**RE: Overture Senior Active Adult
6410 Palomas Ave NE
Grading and Drainage Plan
Engineer's Stamp Date: 09/20/18
Hydrology File: D18D056A**

Based upon the information provided in your submittal received 09/21/2018, the Grading and Drainage Plan **is not** approved for Building Permit and Grading Permit. The following comments need to be addressed for approval of the above referenced project:

ENGINEER'S SEAL 	<b>OVERTURE SENIOR ACTIVE ADULT</b>	DRAWN BY DY
	<b>GRADING AND DRAINAGE PLAN</b>	DATE 10/09/18
 TIERRA WEST, LLC 5571 MIDWAY PARK PLACE NE ALBUQUERQUE, NM 87109 (505) 858-3100 www.tierrawestllc.com		2017086-GRB
		SHEET # C2
JOB # 2017086

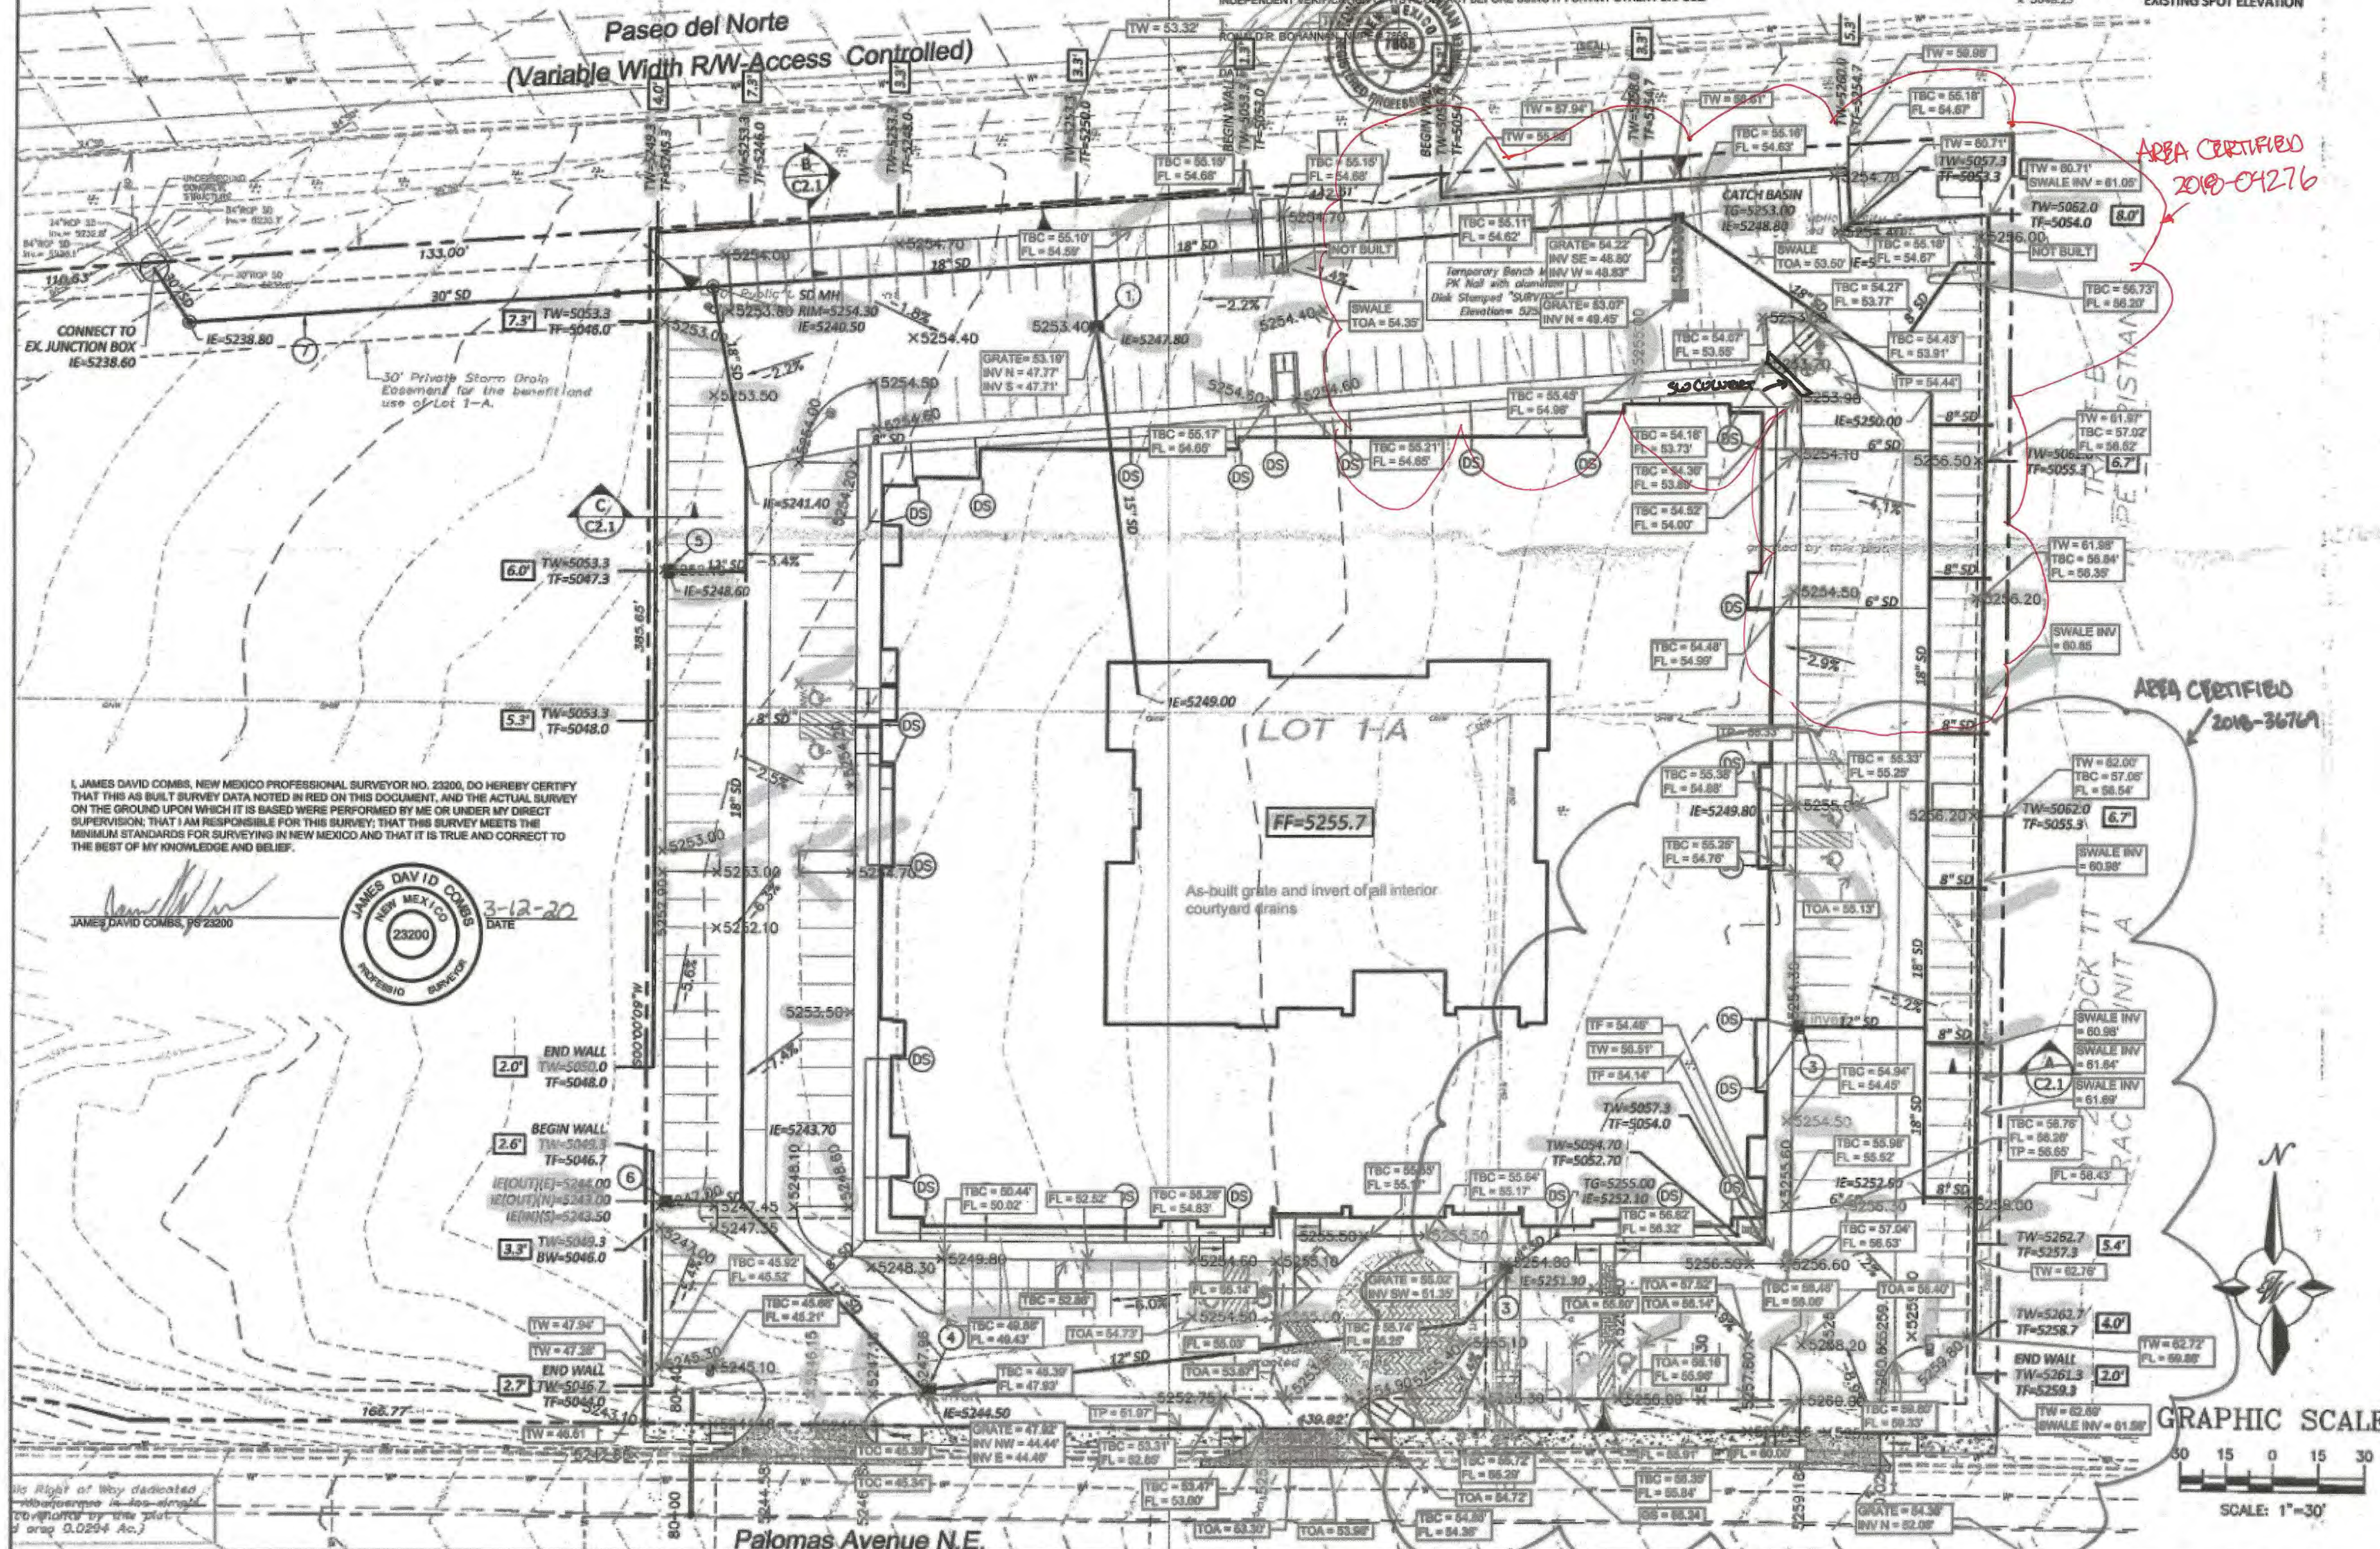
1. The site currently shows more than 1 acre of disturbance is being proposed. An Erosion and Sediment Control Plan is required and has to be submitted to the storm water quality engineer (Curtis Cherne, PE, ccherne@cabq.gov). Hydrology's approval for Grading or Building Permit will not be given until the submittal of the ESC Plan.
2. Please provide the FIRM Map's effective date.
3. Please provide the benchmark information for the survey contour information provided.
4. Please provide a section of the proposed retaining wall along Paseo del Norte near the Northwest corner of the site and a section of the proposed retaining wall along the Western property line.
5. Please add a note requesting a waiver for the first flush volume requirement. Also add a note stating, "The required first flush volume for the 142,764.70 SF of impervious cover is 4,045 CF."
